Construction of 1No. 2 bedroom chalet bungalow
Land adj to 65B Gravits Lane Bognor Regis

Thank you for your internet representation made on 10th September 2014 which has been recorded as '**an objection**' with the comments as follows:

BLOCK / LOCATION PLAN
LAND ADJACENT TO 65B GRAVITS LANE BOGNOR

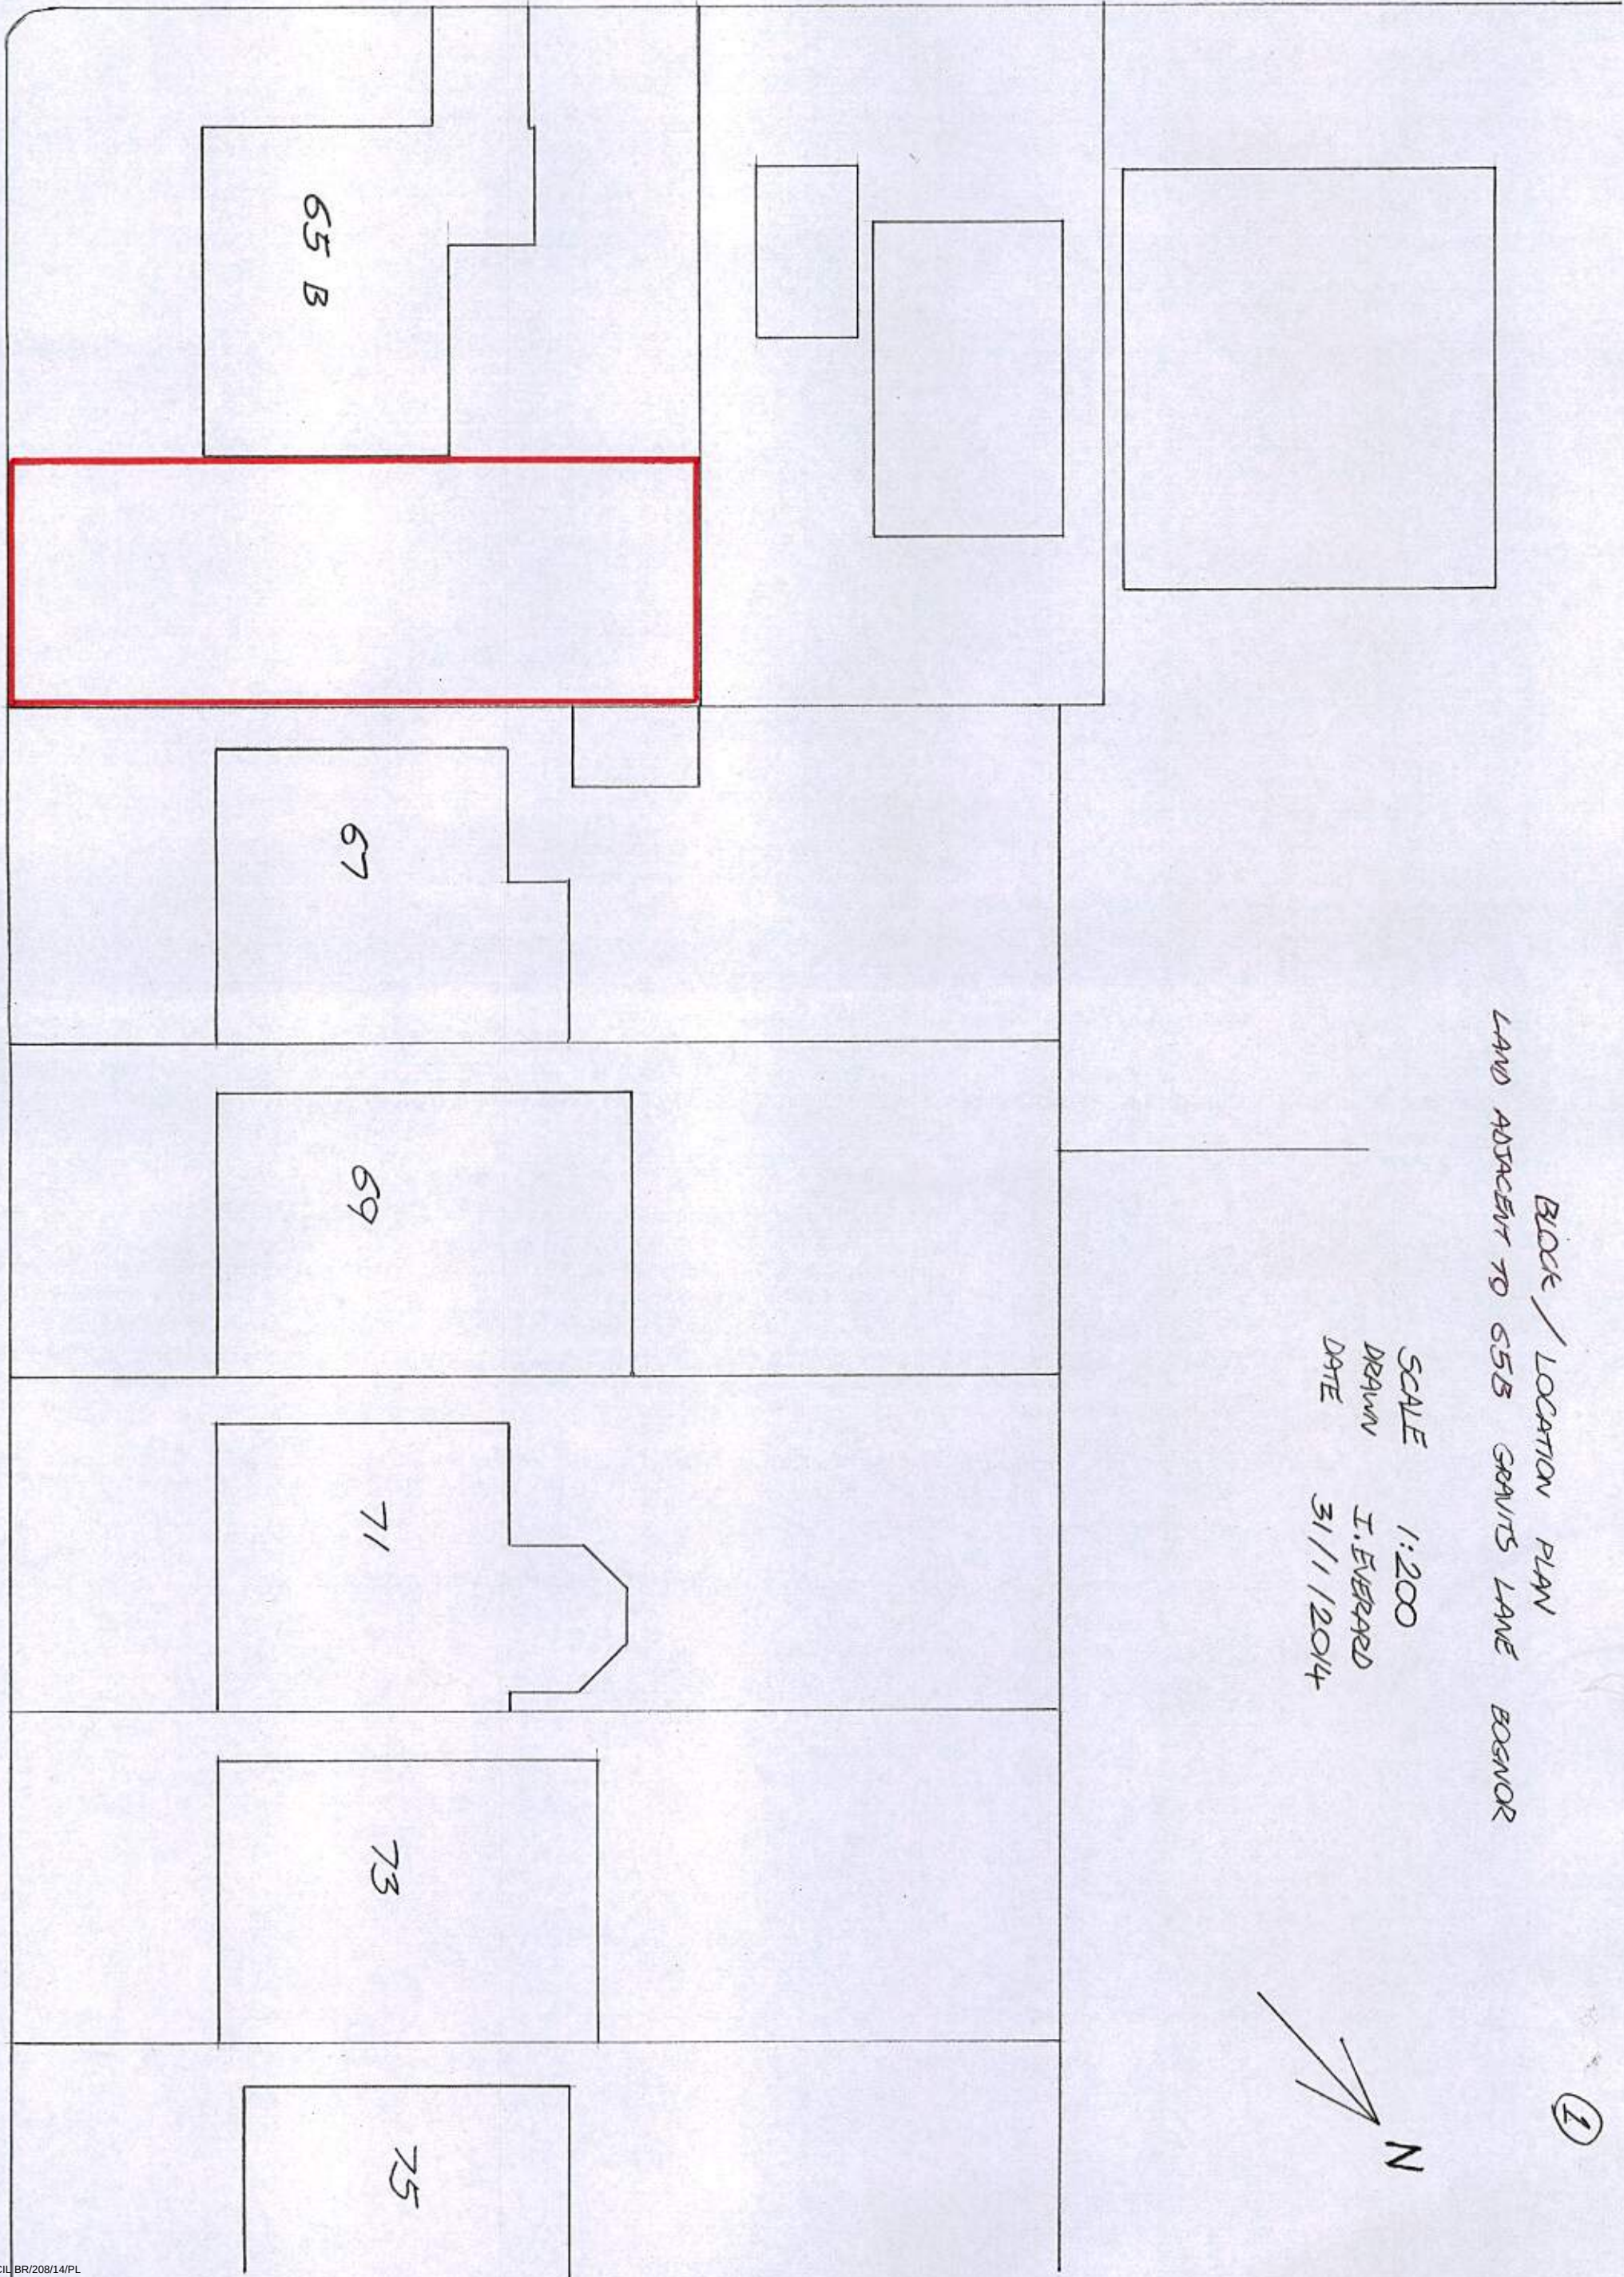
The off-street parking for 65b will be much closer to the corner of Ivydale Road and Gravits Lane, the corner is obscured by the wall and any vehicles parked in Ivydale, so anyone turning from Ivydale into Gravits Lane will have very little time to see if someone were manoeuvring in or out of the off street parking at 65b.
